**Rezoning Transportation Analysis**  
**Petition Number: Insert Zoning Petition #2021-060**  
*General Location Identifier: 09509220*

**Revision Log:**

Date	Description
05-27-2021	First Review (WB)
08-23-2021	Second Review (WB)
09-17-2021	Third Review (KP)

**General Review Information**

**RZ-1.0**

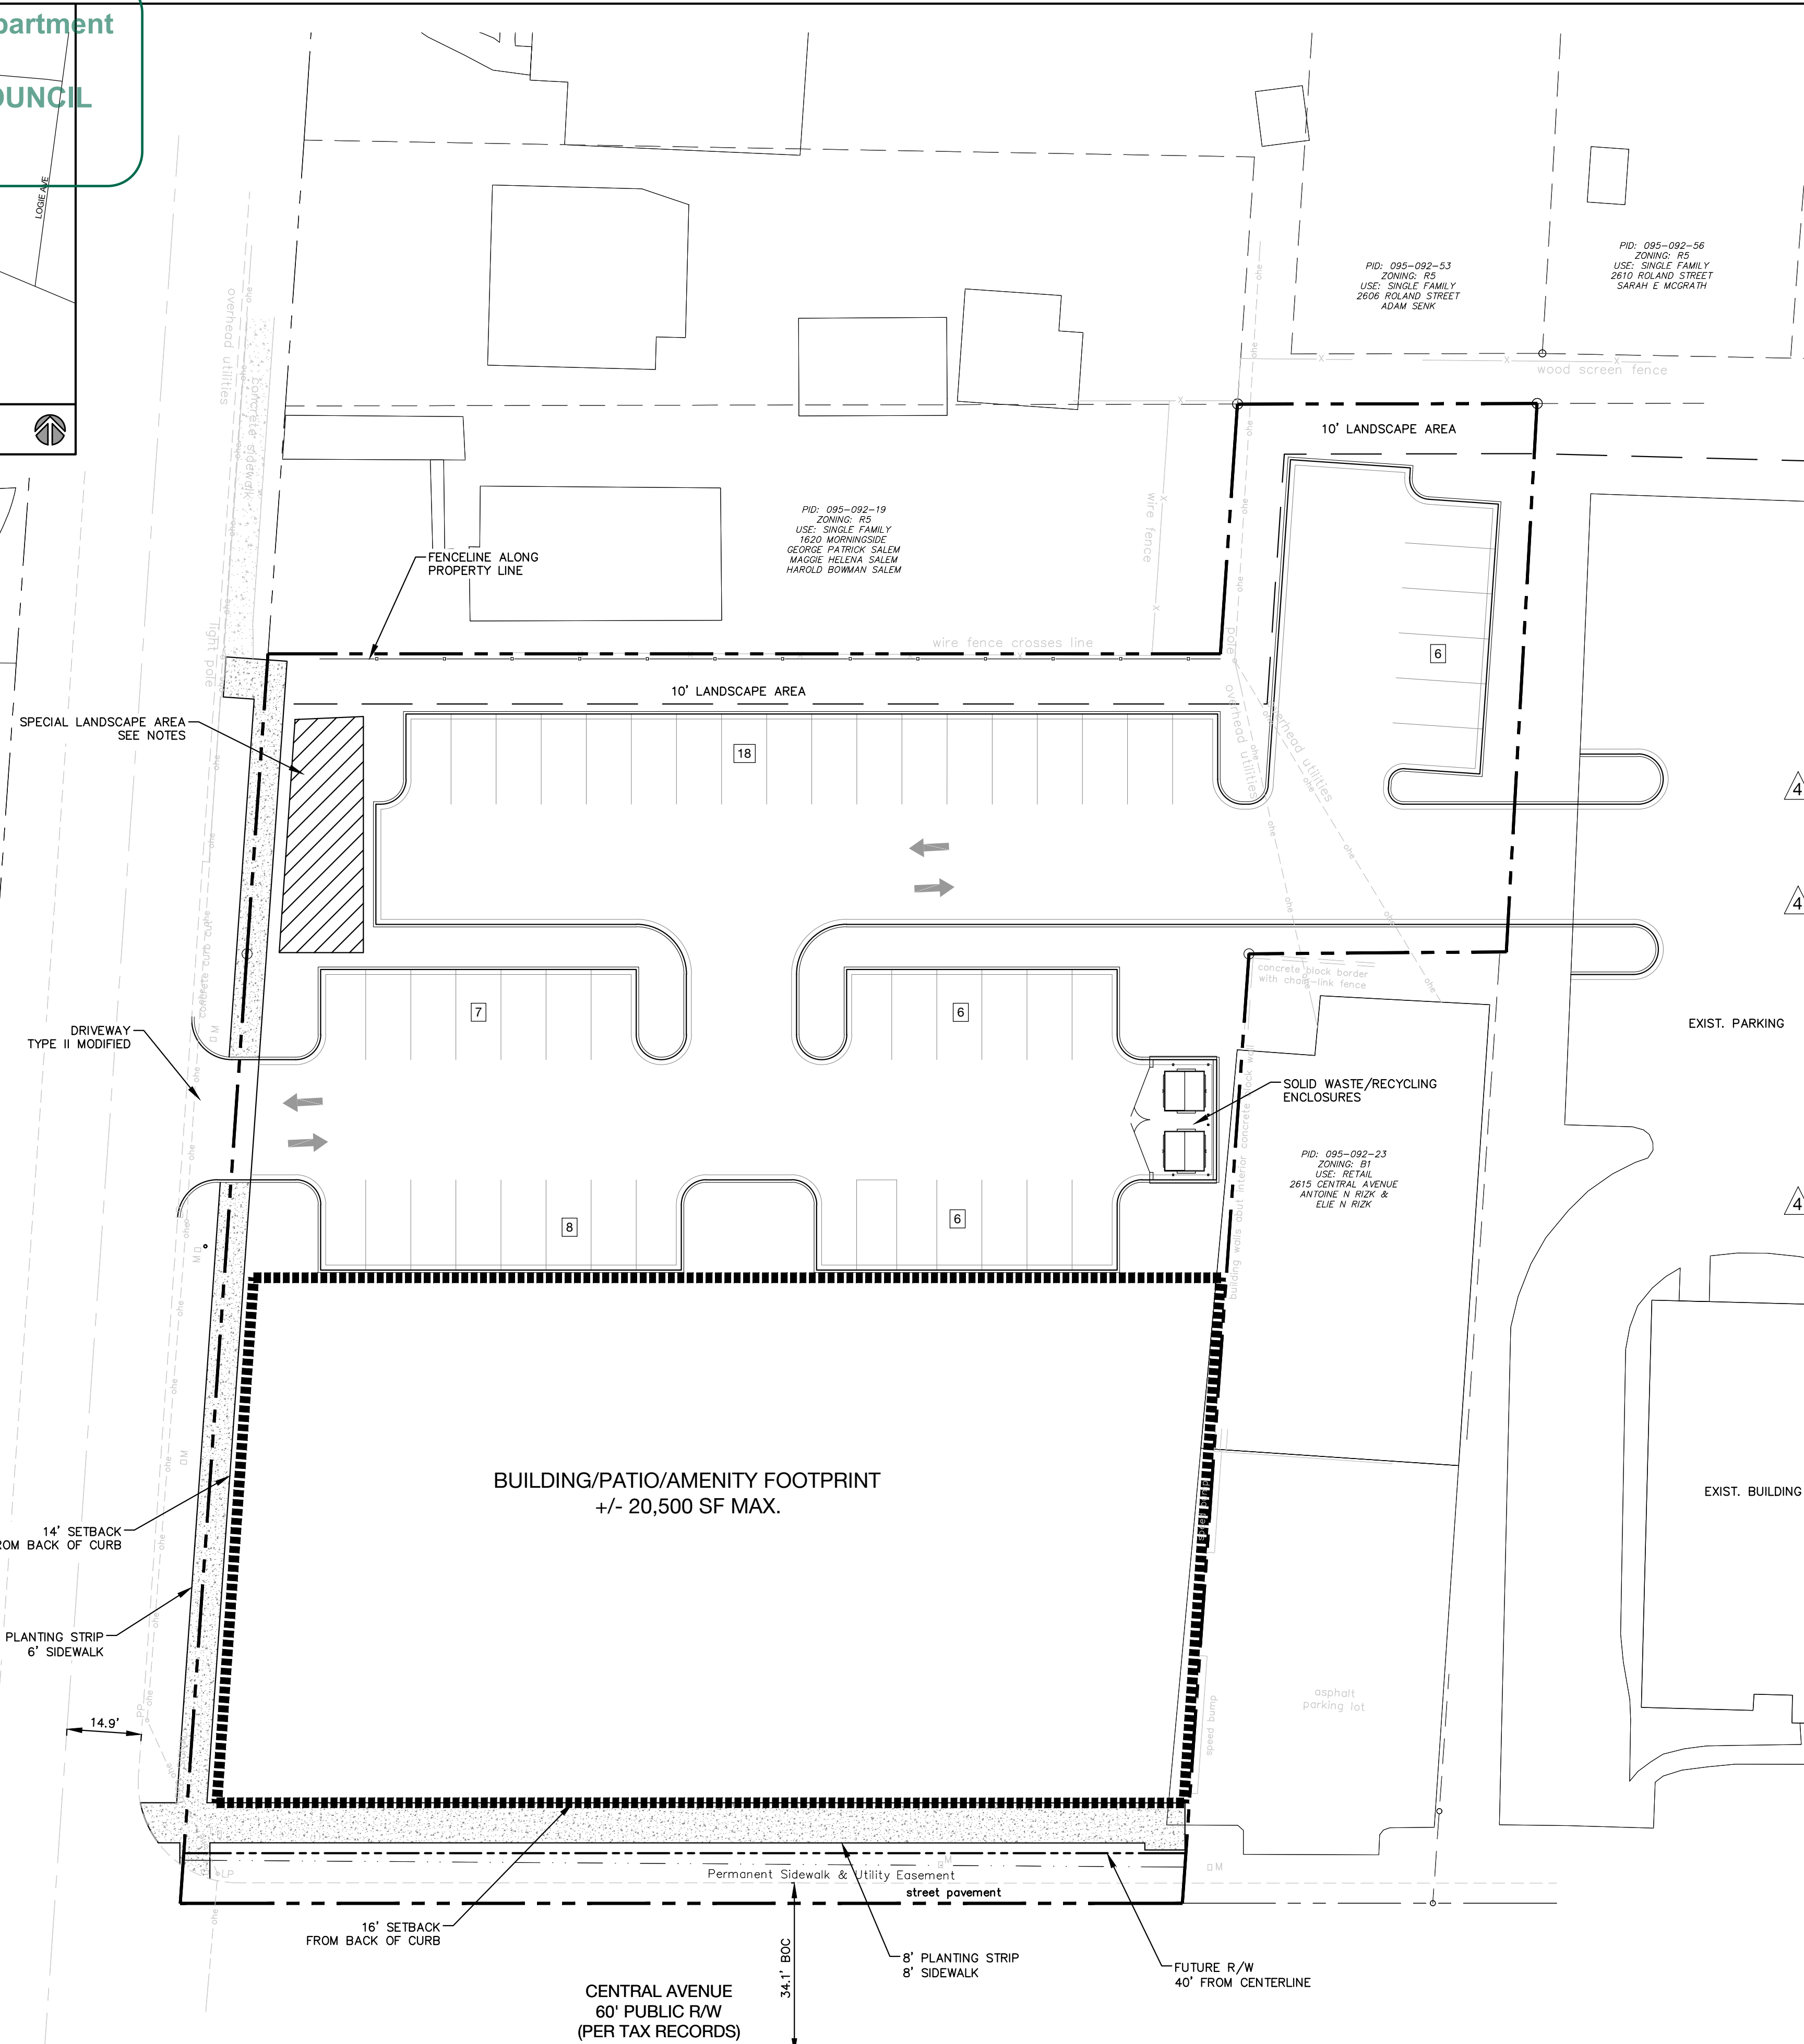
1. ~~**Curbline:** The proposed zoning district has a setback measured from back of the existing or proposed future curbline.~~
  - a. ~~**Central Avenue:** The future location of curb and gutter is in its existing location.~~
  - b. ~~**Morningside Drive:** The future location of curb and gutter is in its existing location.~~

~~Label and dimension the curb and gutter from the centerline for each road on the site plan.~~
2. **Traffic Study:**  
~~A Traffic Impact Study (TIS) is not necessary for the complete review of this petition due to the site generating less than 2,500 daily trips. If during the permitting process the site generates more than 2,500 daily trips, then a traffic study will be required.~~
3. ~~Site plan and conditional note(s) revisions are needed to install two curb ramps at the Central Avenue and Morningside Drive Intersection per ADA law and PROWAG standards.~~
4. **REVISED COMMENT (08.23.2021)** Modify the conditional notes, by including a note regarding dedication and fee simple conveyance of all rights-of-way to the City before the site's first building certificate of occupancy is issued. ~~CDOT requests rights-of-way set at 2' behind back of sidewalk where feasible.~~
